re. ADC Application Ref: P/157/21/PL

Property: 31 Lagoon Road, Pagham, PO21 4TQ

Proposal: Demolition of existing sub-standard dwelling and erection of new dwelling

PROJECT TITLE: 31 Lagoon road
DRAWING TITLE: Street Scene
DRAWING TYPE: Proposed
DRAWING NUMBER: B_300
SCALE: 1:200 @ A3
DATE: NOV '21

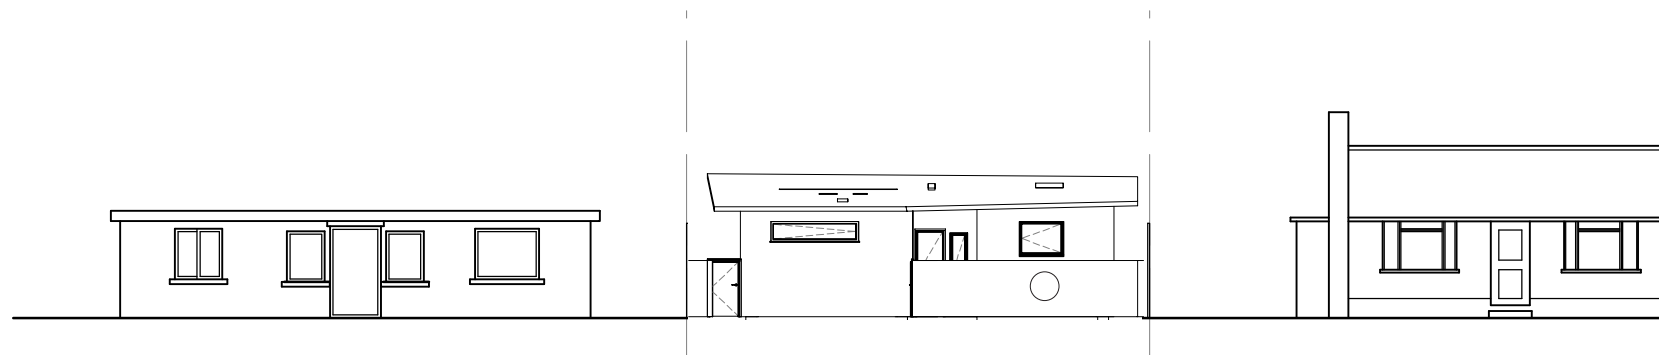
3. The Application Proposal includes the provision of a courtyard to enclose the main entrance to Building A. I have previously requested to be advised the height and nature of construction of this courtyard wall as it is constructed on the front boundary of the Application Site and will have a negative impact on the street scene in this locality. The information requested has not been forthcoming and in these circumstances I assume that the Planning Authority will request this detail.

DRAWING NUMBER: B_200

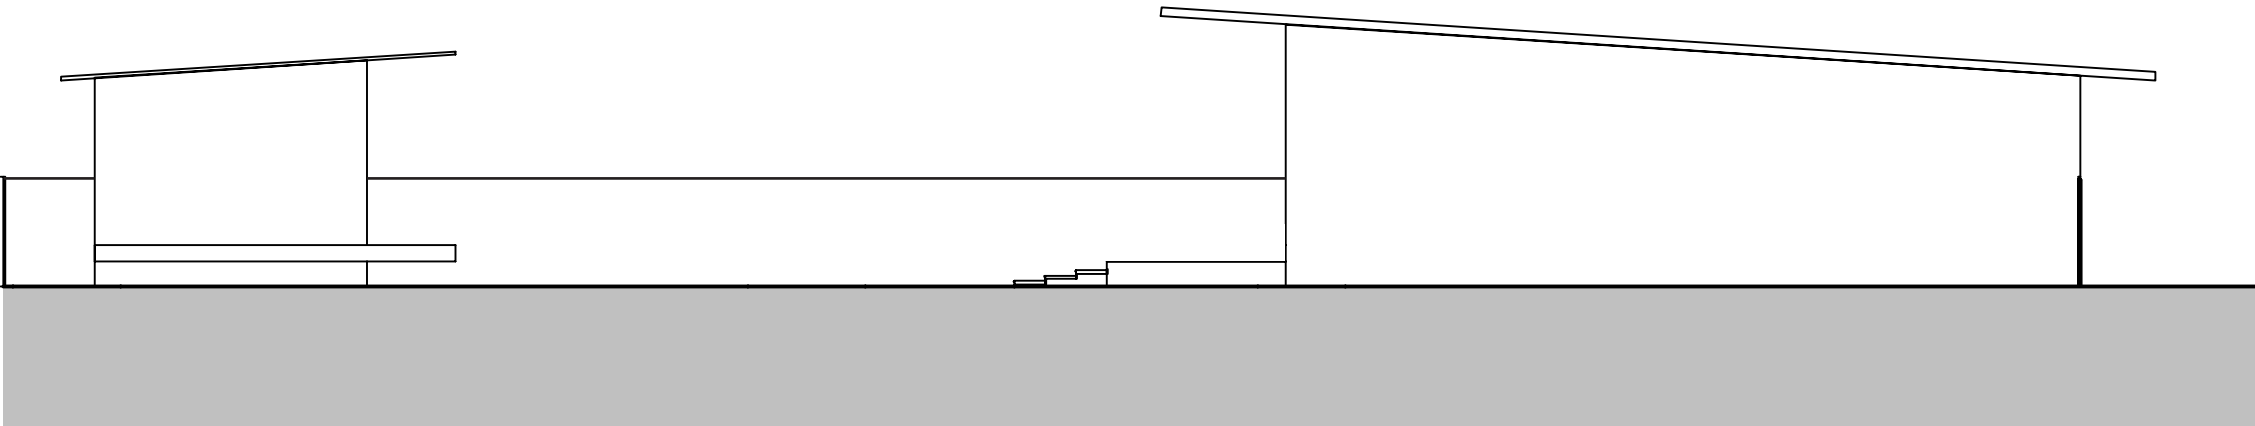
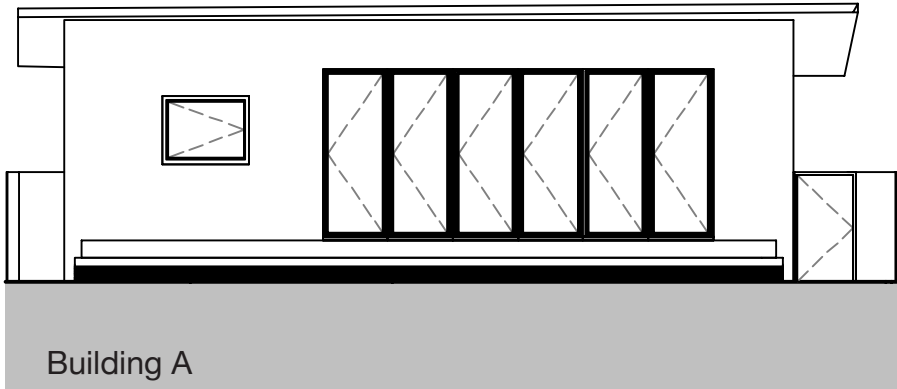
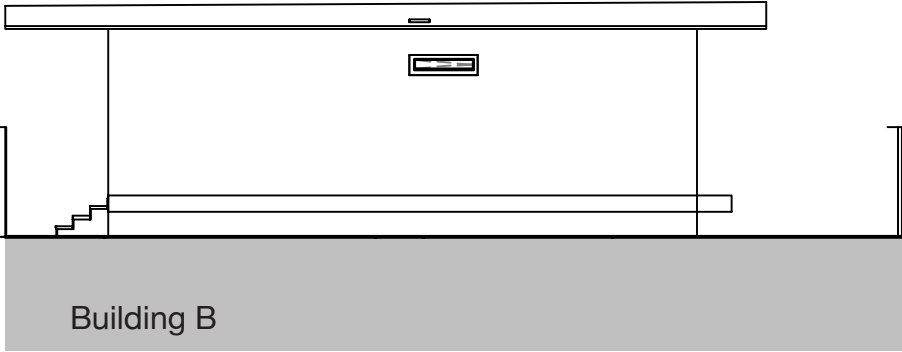
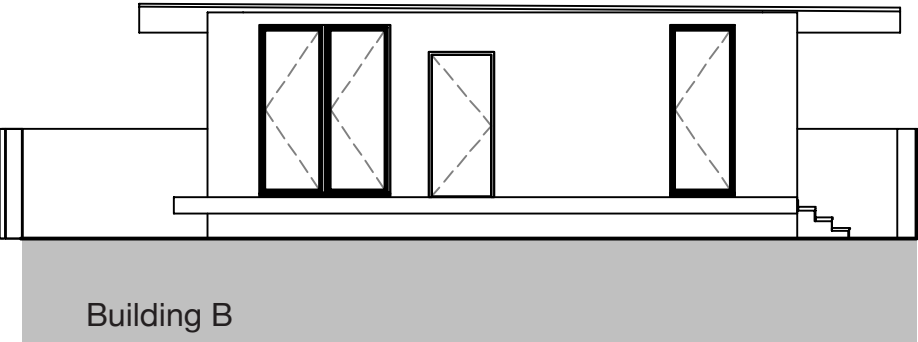
1. Although the Application is described as a "new dwelling" the actual proposal is the erection of two detached single-storey buildings, Building A comprising a 1-bedroom bungalow with kitchen, bathroom and reception room, and Building B comprising two bedrooms and a bathroom, clearly erected to be used as a holiday let, possibly in conjunction with building A but not necessarily. This proposal constitutes a Change of Use, which I am surprised the Planning Authority has not requested be Approved.

2. The construction of the proposed new buildings is described as straw bale construction, although the design and layout of the two buildings does not accord with the module of modern straw bales and will need to be amended to suit this construction. You will be aware from my earlier letter direct to the Applicant that I have expressed concern that this form of construction with limecrete render is unlikely to achieve the required fire protection required by Approved Document B of Building Regulations, which will be required in view of the proximity of the proposed buildings to neighbouring bungalows, both in Lagoon Road and Harbour Road, as a result of the proximity of the building B to the rear boundary.
